Appeal Decision

Appeal Ref: APP/Z4718/D/22/3307523

75 Imperial Road, Edgerton, Kirklees, Huddersfield HD1 4PG

- The appeal is made under section 78 of the Town and Country Planning Act 1990 against a refusal to grant planning permission.
 - The appeal is made by Mr Khurram Nisar against the decision of Kirklees Metropolitan Council.
 - The application Ref 2022/62/90514/W, dated 10 February 2022, was refused by notice dated 1 July 2022.
 - The development proposed is single storey rear extension.
-

Drawing Title  
Plans Proposed

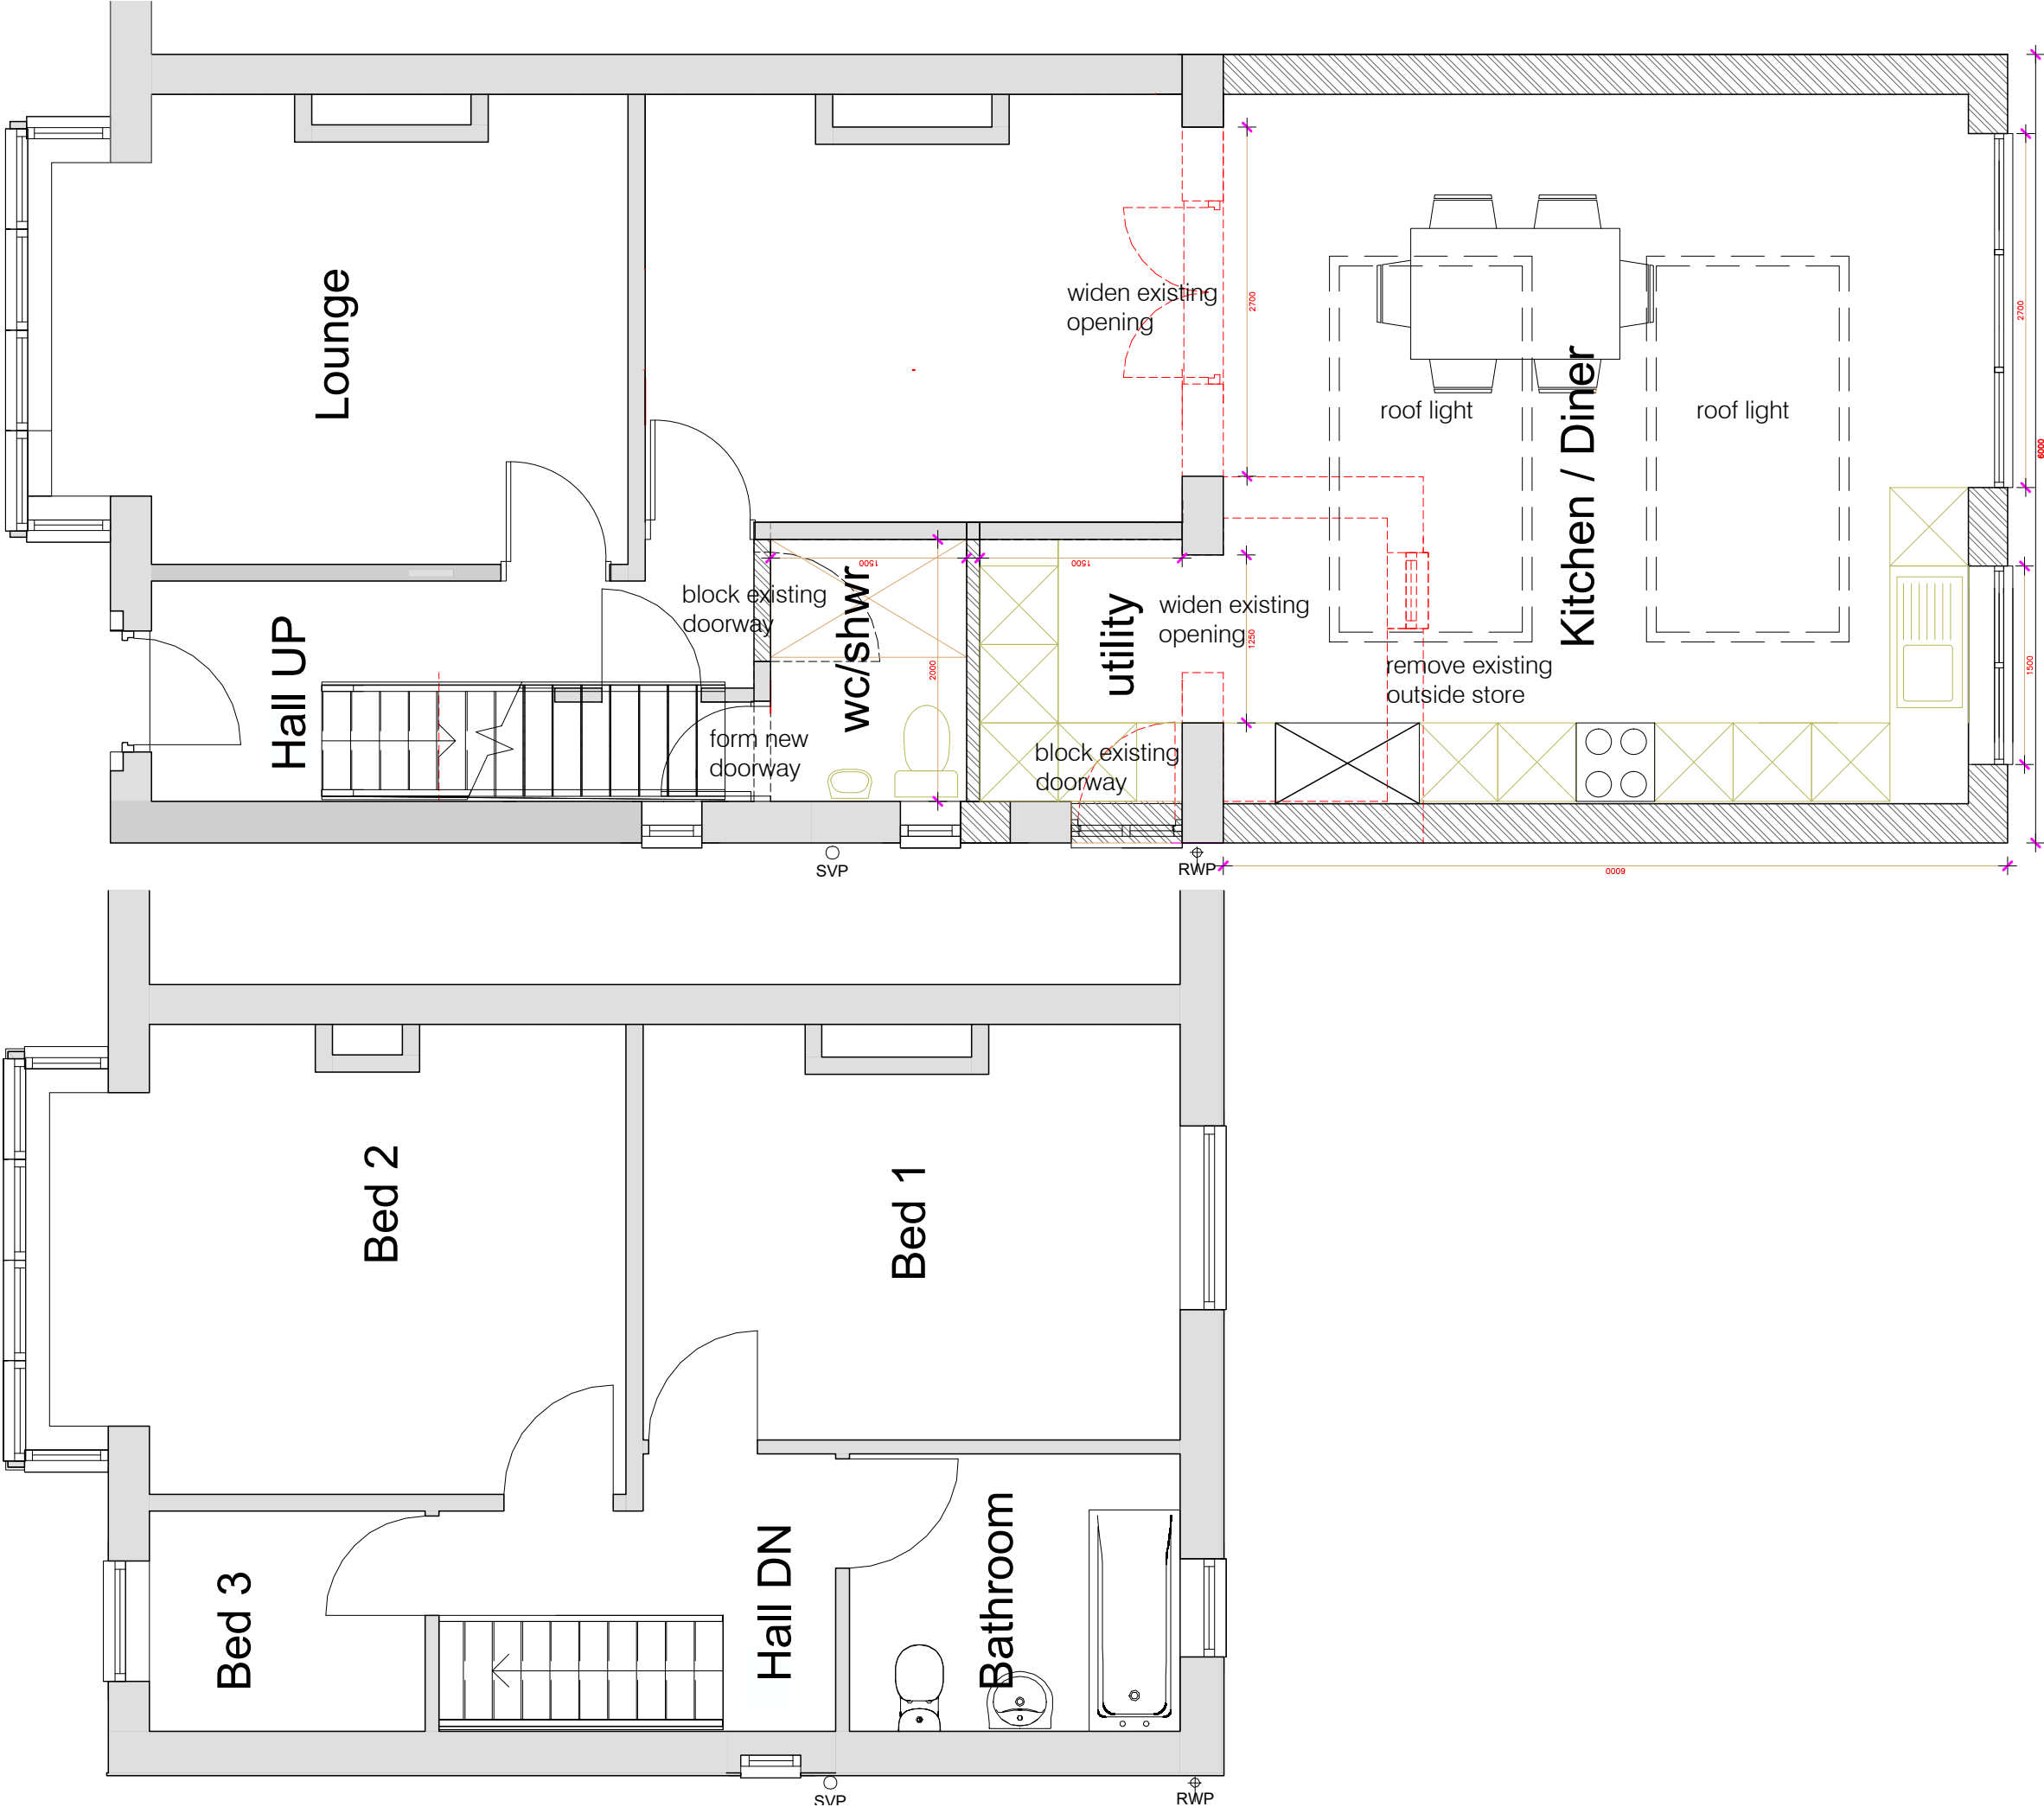
5. The extension would be six metres in depth and full-width, with one elevation constructed on the shared boundary with 77 Imperial Road. As a consequence, it would cover a significant proportion of the rear garden and would appear as an uncharacteristically large addition. The principle of an extension to the property is acceptable. However, the rear extension's significant depth would result in an addition which would be out of scale with the building and would appear as an overly dominant and unbalancing feature. This would not be mitigated by the proposed materials which would match with the property's existing facing materials.

7. The Council refer to its House Extensions and Alterations SPD (2021) (SPD). In respect of single storey rear extensions the guideline maximum projection set by the SPD is 3 metres for semi-detached properties. The SPD also suggests the retention of a 1 metre gap from the property boundary and a maximum eaves height of 2.5 metres where extensions exceed 3 metres in length. The rear extension would conflict with each of these SPD guidelines for single storey rear extensions.

Drawing Title
Proposed Block Plan

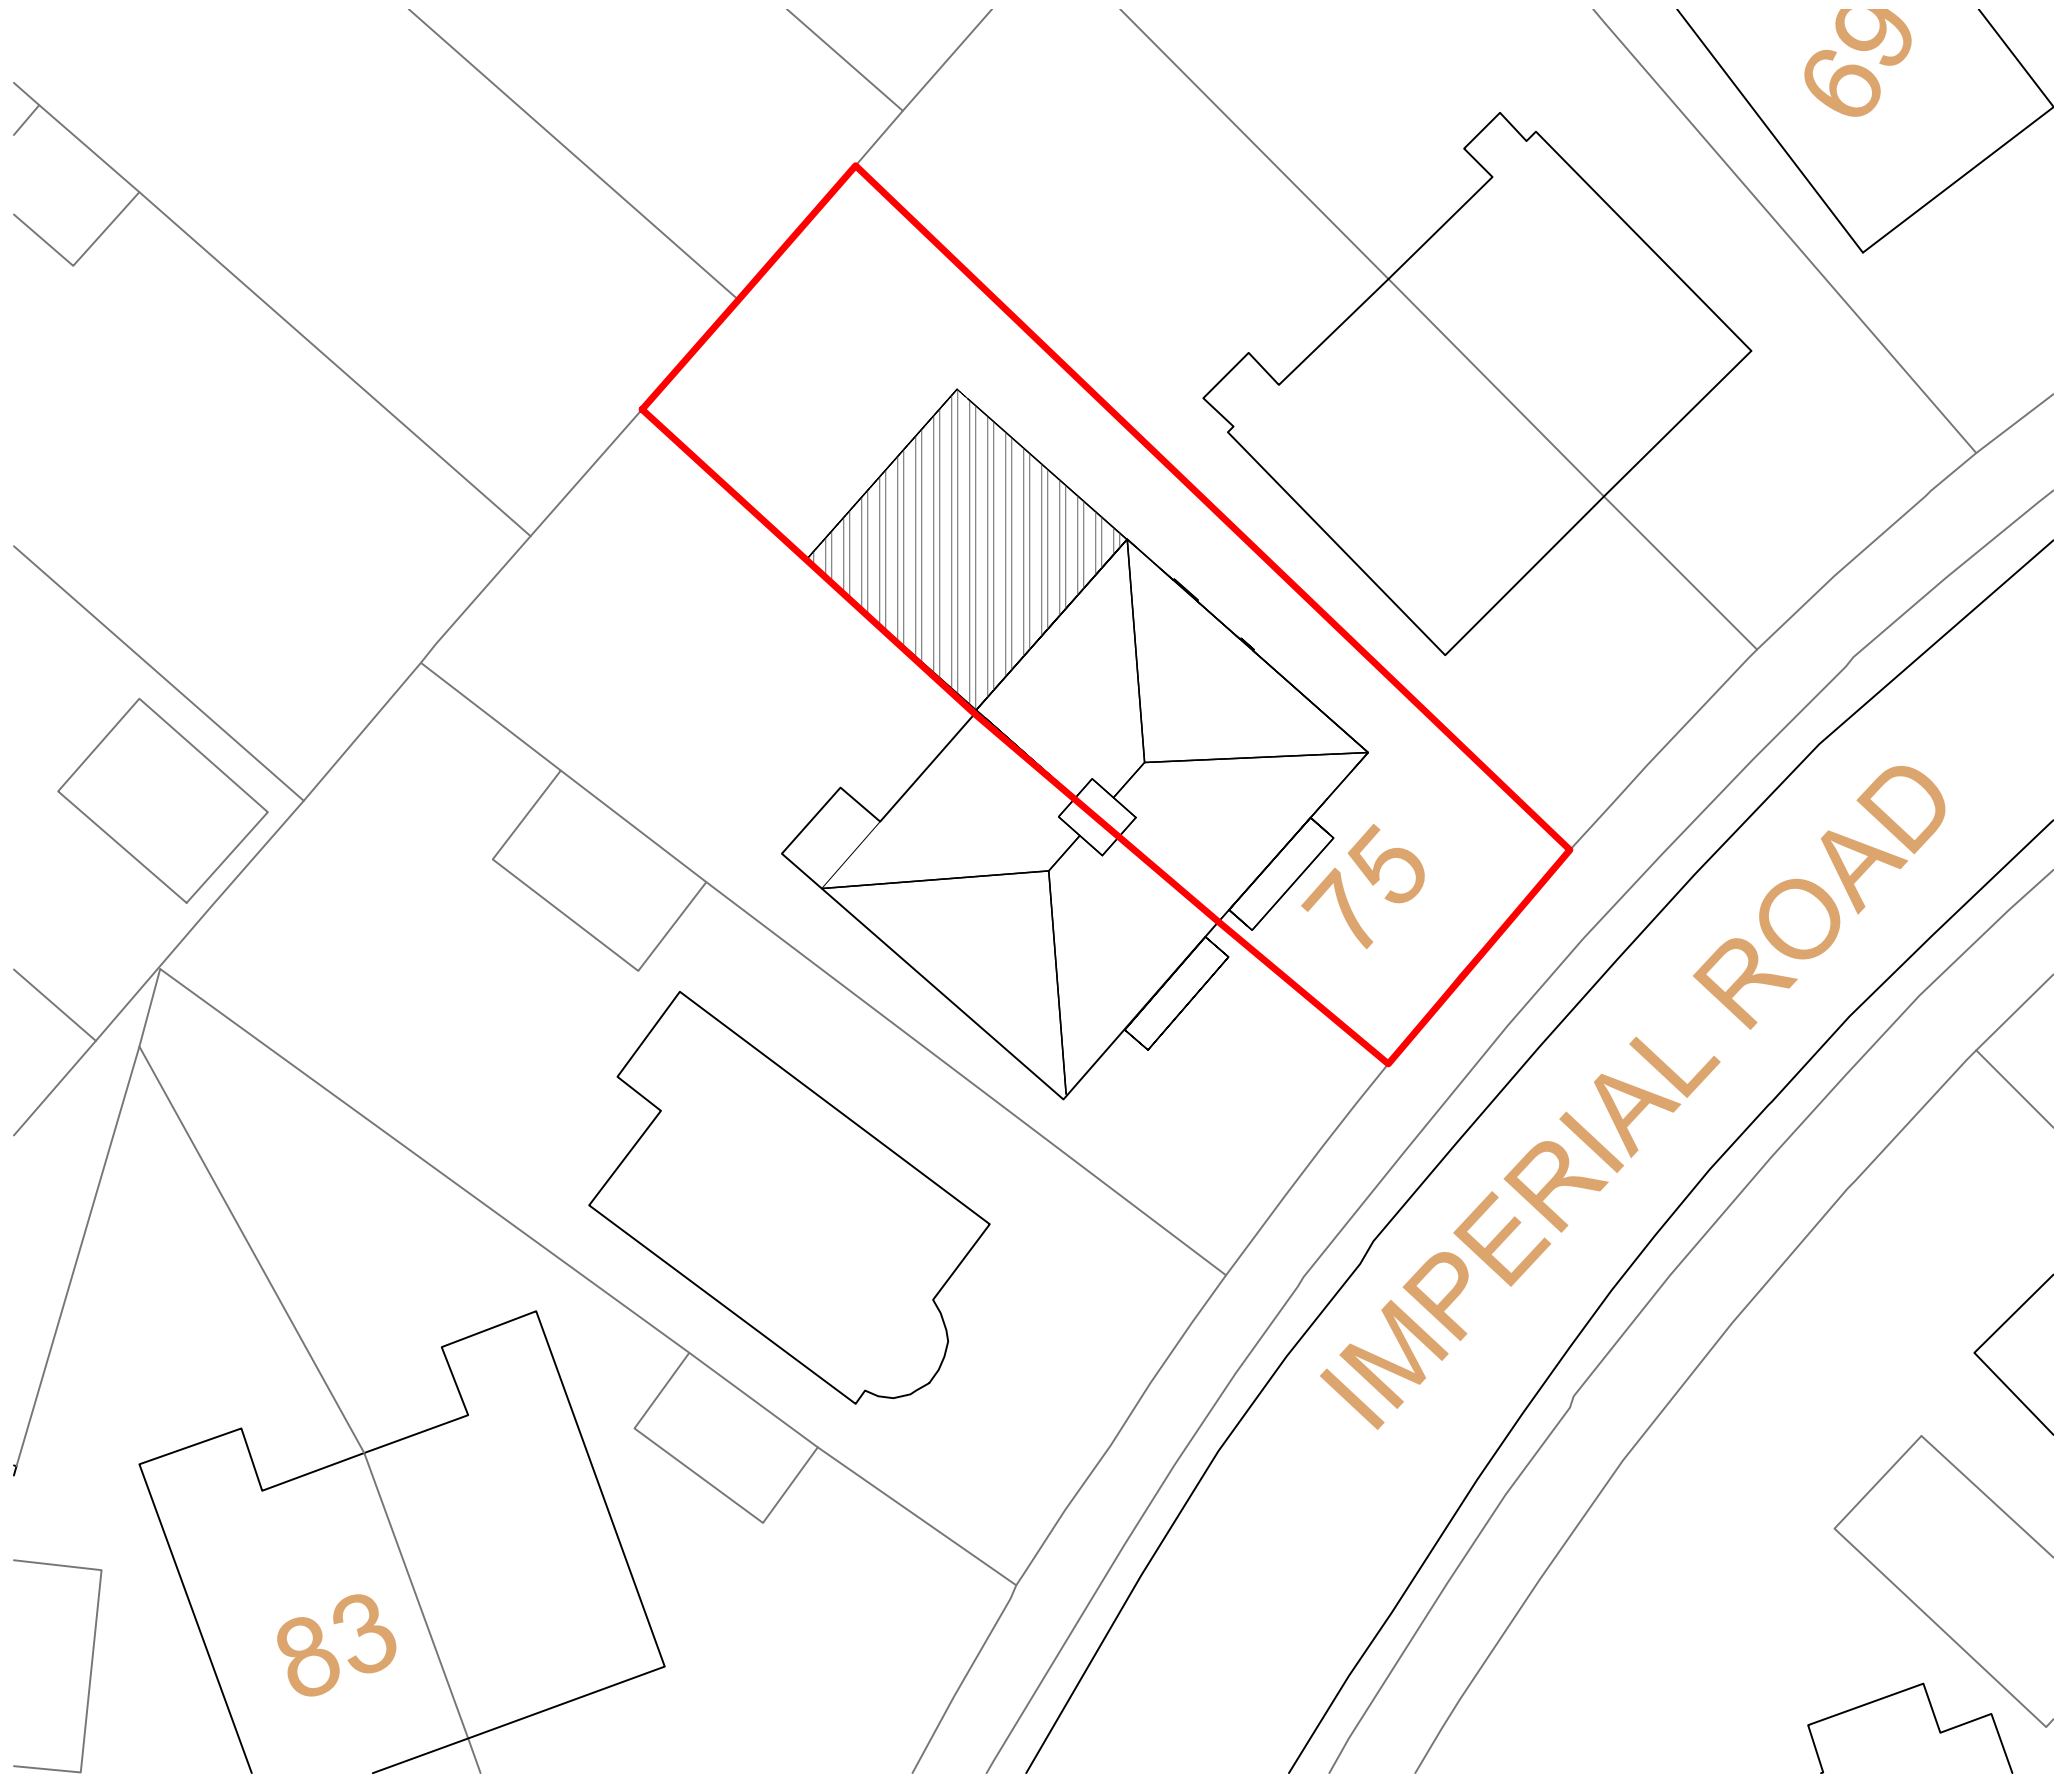
11. As the extension would be built right to the shared boundary with 77 Imperial Road its depth has the potential to impact both the outlook and level of light

Side Elevation Proposed -
view from adjacent property

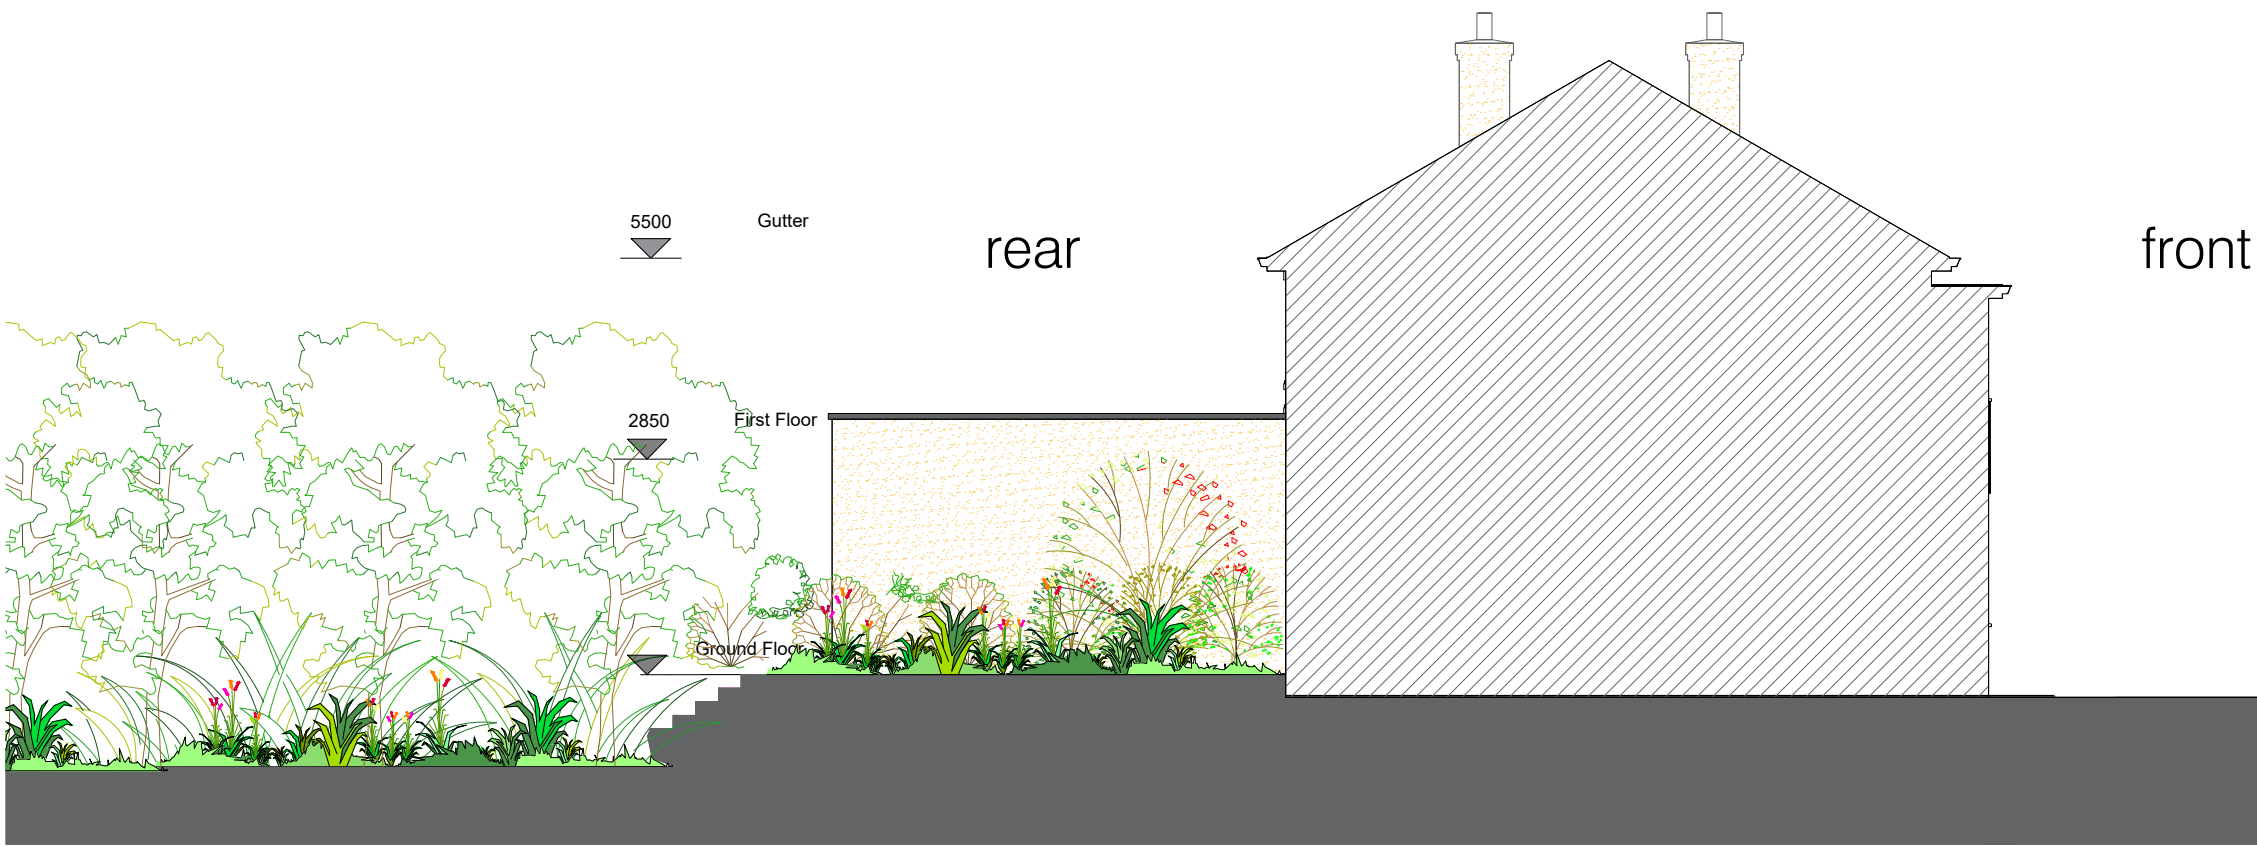
for occupiers of the neighbouring property. Similarly, I have concerns with the height of the extension which, the appellant confirms, would have a maximum height of 3.5m on the boundary with the neighbouring property.

12. No. 77 has glazed doors on its rear elevation which appear to supply a habitable room. Given that the doors are only a short distance from the shared boundary, the extension would be highly visible from within the room. The extension would replace natural hedging which is approximately 1.5 metres in height, with a uniform height brick wall of 6 metres depth and with no softening features. Whilst the extension may provide additional privacy to the occupiers of adjoining property, it would have a looming presence when viewed through the glazed doors and also when viewed from the garden area immediately outside No. 77's rear elevation. The combined depth, height and proximity of the proposed rear extension to the neighbouring property's habitable windows mean that the proposed development would have an adverse impact on the living conditions of neighbouring occupiers in terms of a sense of enclosure and thus a loss of outlook.

13. The presence of an extension of this depth, height and with limited separation from No. 77's ground floor glazed doors would also overshadow these during the morning period, and potentially for longer periods during the winter months. Overall, I find that the extension, in such close proximity, would substantially reduce the amount of daylight and sunlight reaching the accommodation. The appellant has submitted three dimensional modelling as part of an overshadowing study which seeks to demonstrate that the extension would not have a harmful effect on the occupiers of No. 77. However, the study does not include a methodology to demonstrate how the findings of the overshadowing study were achieved. Consequently, I afford the study limited weight. The proposed extension would clearly conflict with the guidelines set out in the Council's SPD which suggests that extensions should not breach the 45 degree rule, when measuring from the nearest habitable room window.
